**From:** Sue Howell <Sue.Howell@arun.gov.uk>  
**Sent:** 21 July 2022 16:58  
**To:** Planning.Responses <Planning.Responses@arun.gov.uk>  
**Cc:** Katie Sharp <Katie.Sharp@arun.gov.uk>  
**Subject:** Planning Consultation on: CM/48/21/RES

**Application ref:** CM/48/21/RES

**Description:** Approval of reserved matters following the grant of CM/1/17/OUT for the erection of 300 No dwellings within use class E, together with public open space, LAPs, LEAP & ancillary works, including car parking & with access off Church Lane & Horsemere Green Lane. This application may affect the setting of listed building 4 (HSP2) & is not CIL Liable.

**Location:** Land to the West of Church Lane South of Horsemere Green Lane Climping

Fitness Trail Location Plan (NTS)

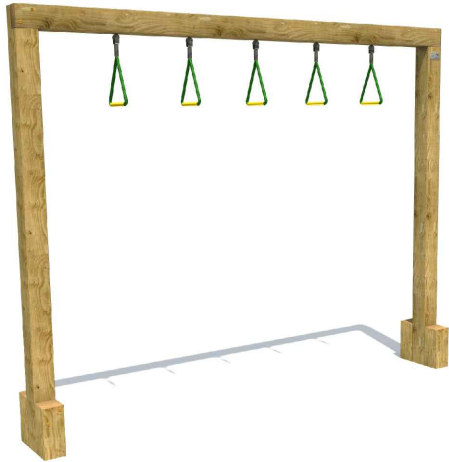
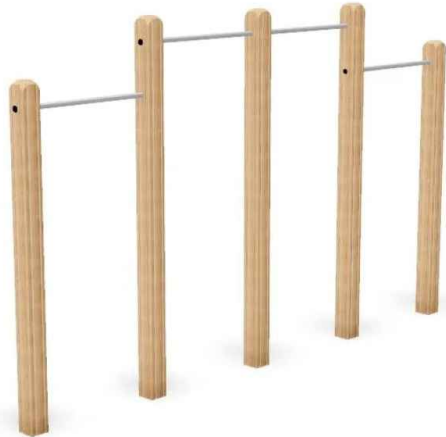
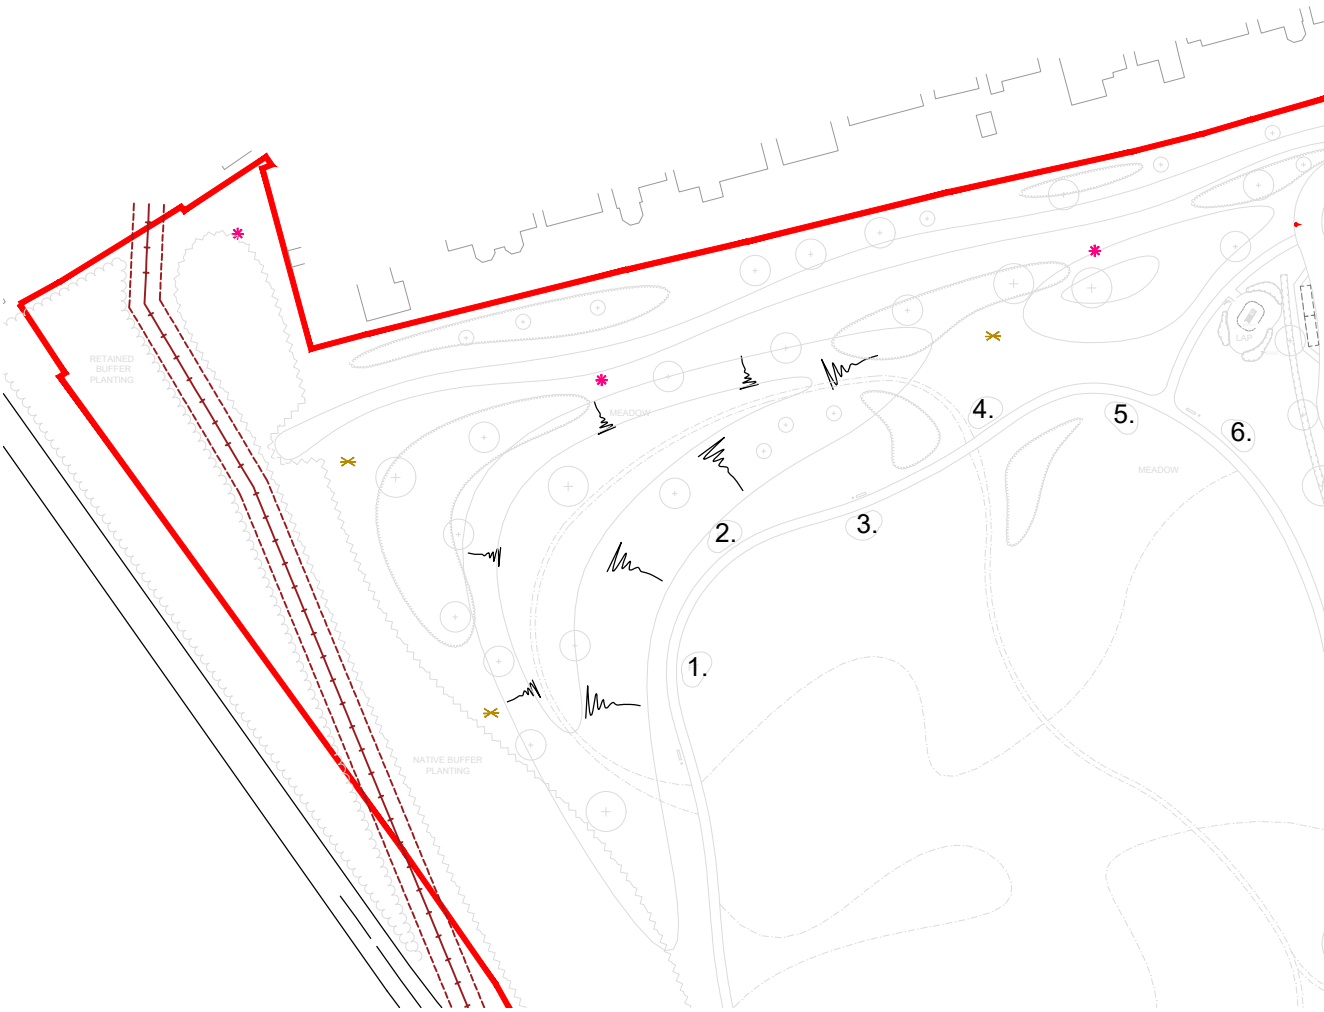
**The fitness trail to the west of the development also appears inadequate.** Fitness trail dwg L11 indicates a poor and basic selection of 6no stand alone pieces, more area than trail with little to excite the imagination or engage the user.

01 Standard - Advanced Nursery Stock Tree Planting in Soft Landscape

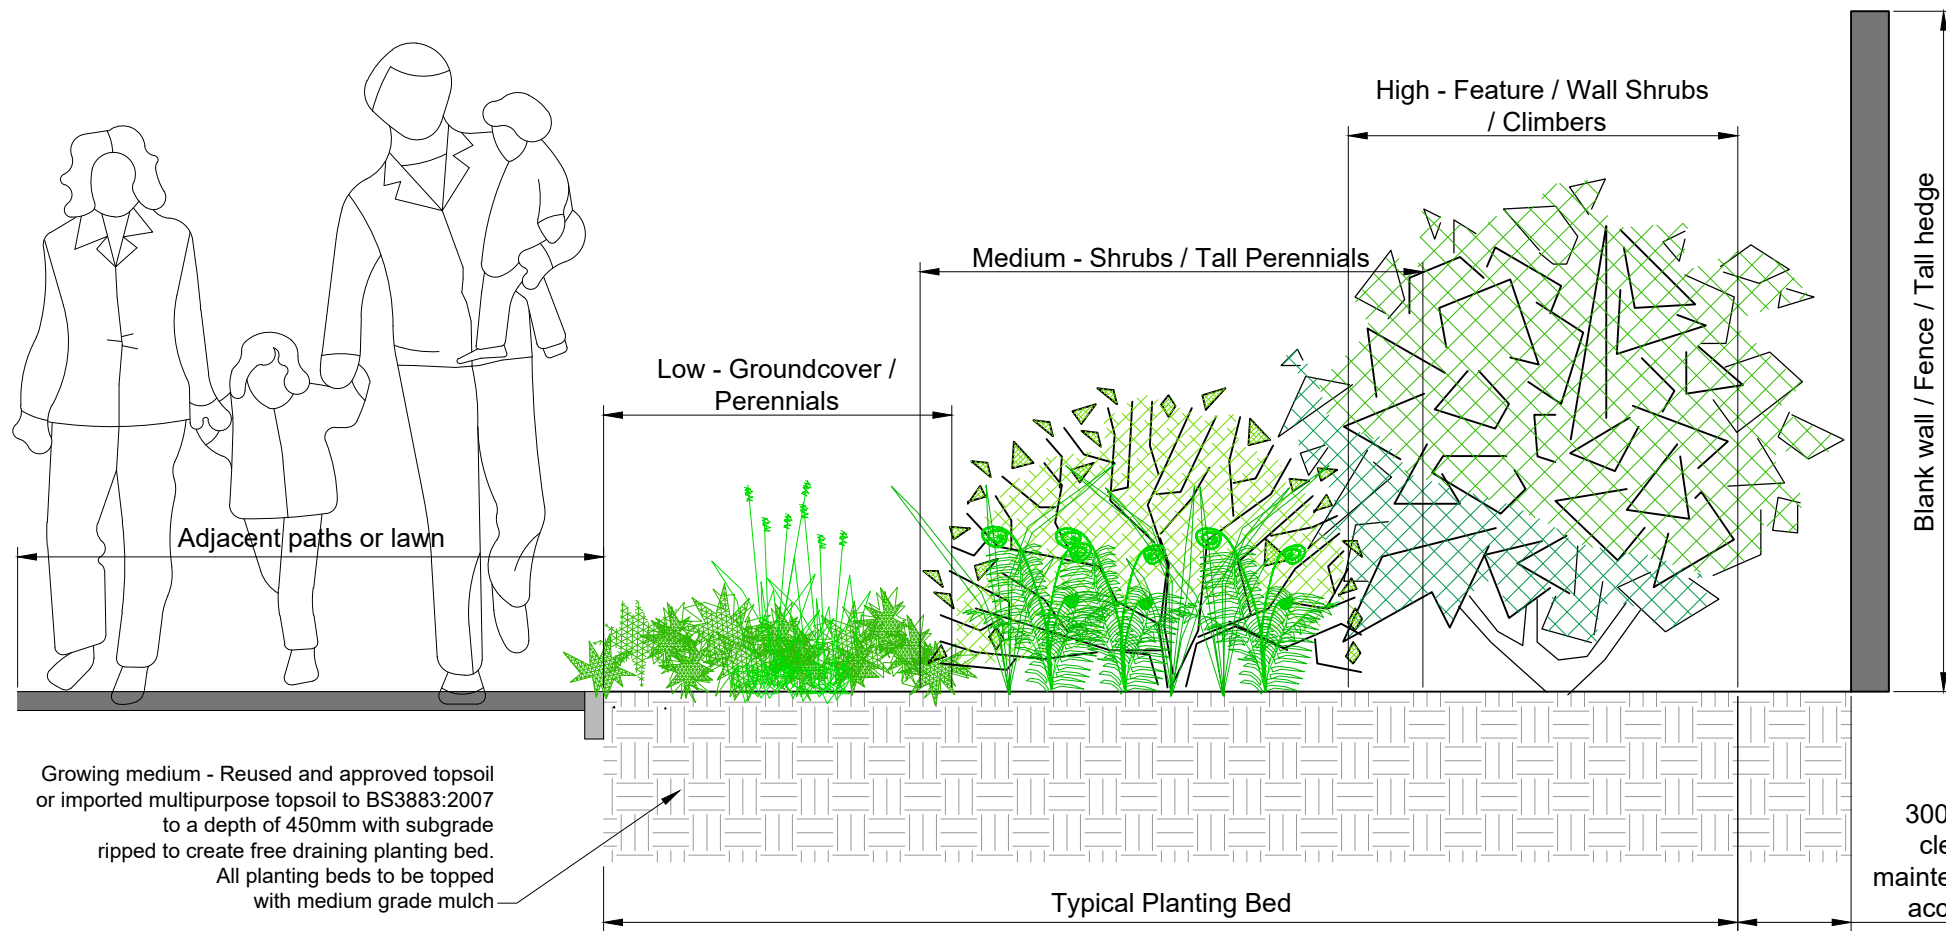
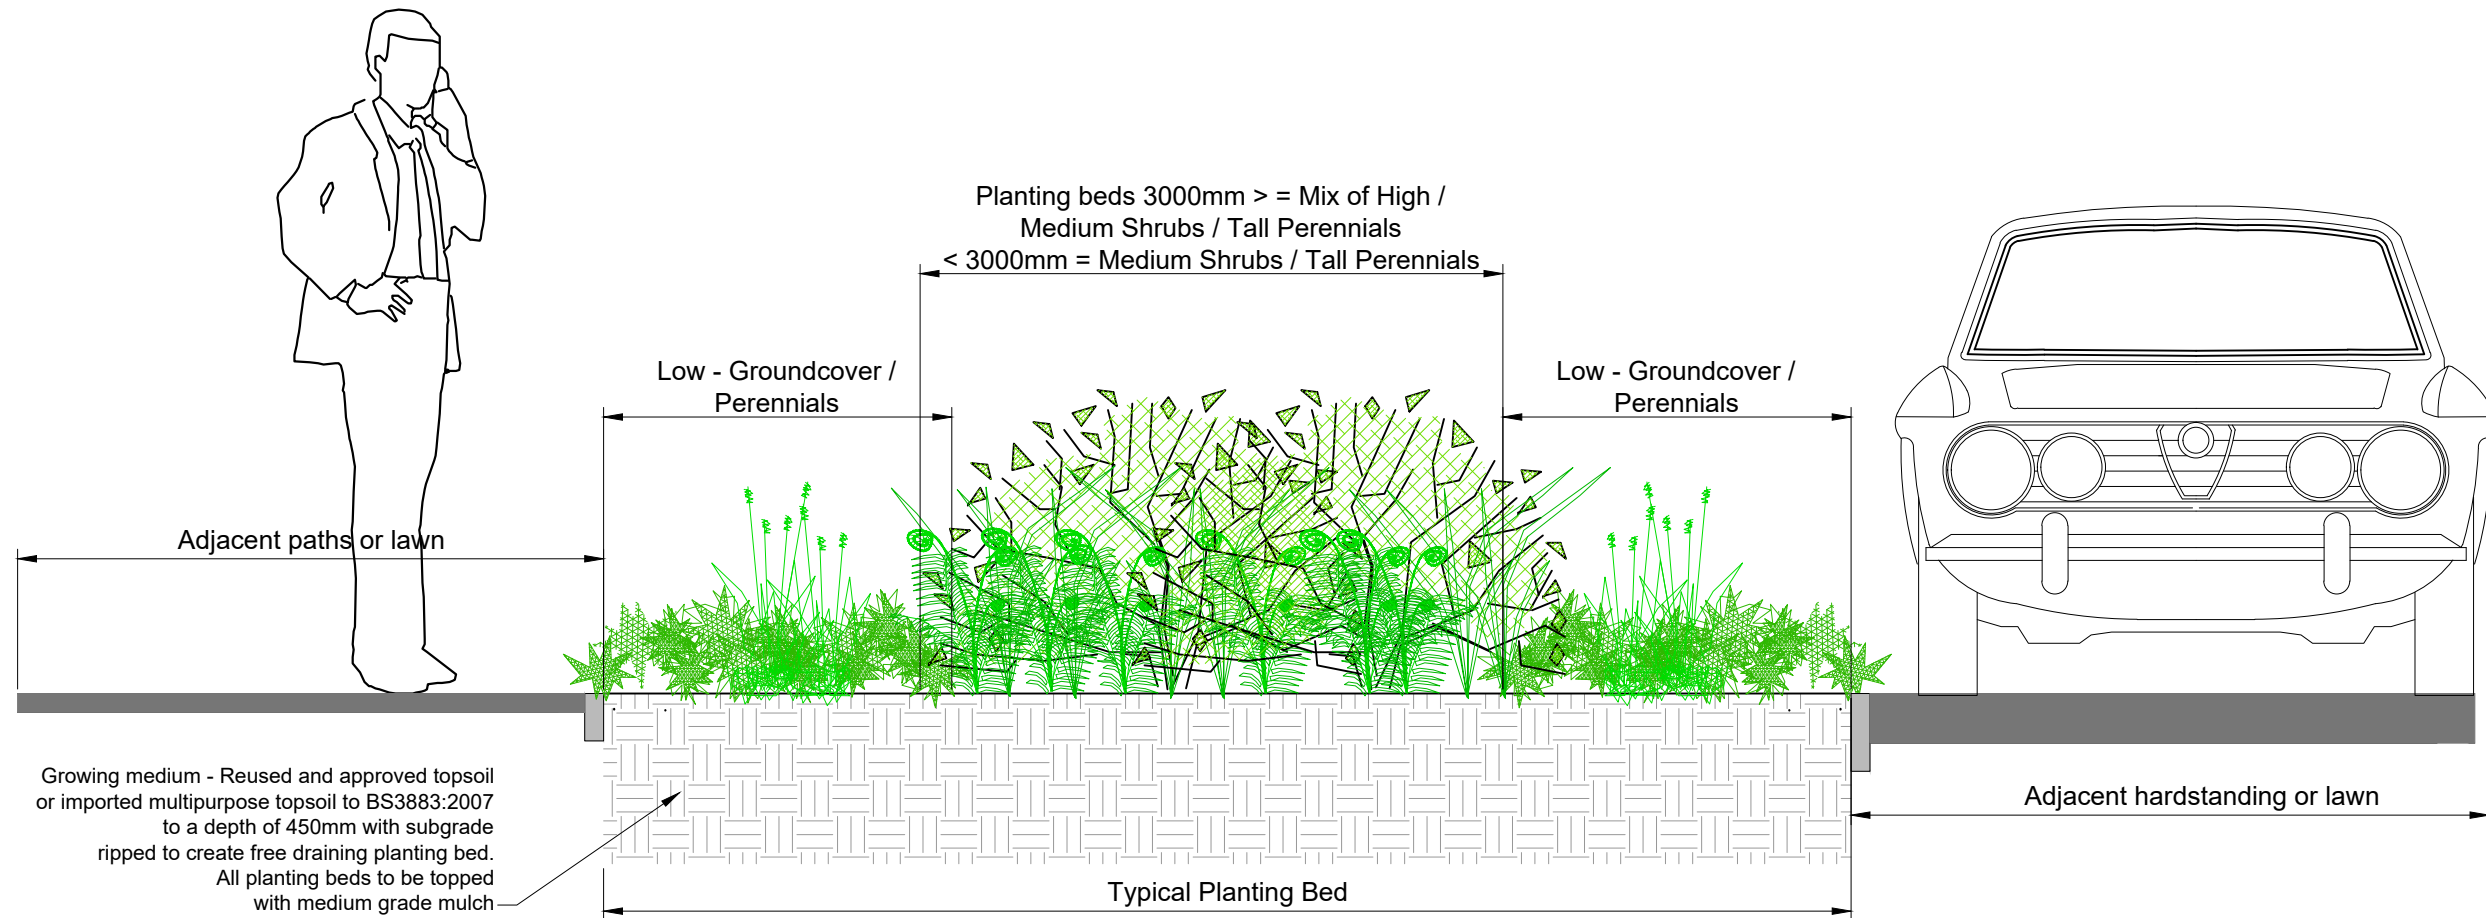
Extensive detailed planting plans have been submitted which are largely suitable for location with species choice and plant specification. **Detailed Planting Plan 20 of 30 which contains the specification needs to show the omitted plant sizes for the Native Buffer planting. Confirmation needs also to be provided re the planting densities** which are shown as 0.1-0.5/m<sup>2</sup> for this element. A planting matrix should be provided in plan form to confirm the proposal for the native buffer and for clarity on planting density of such.
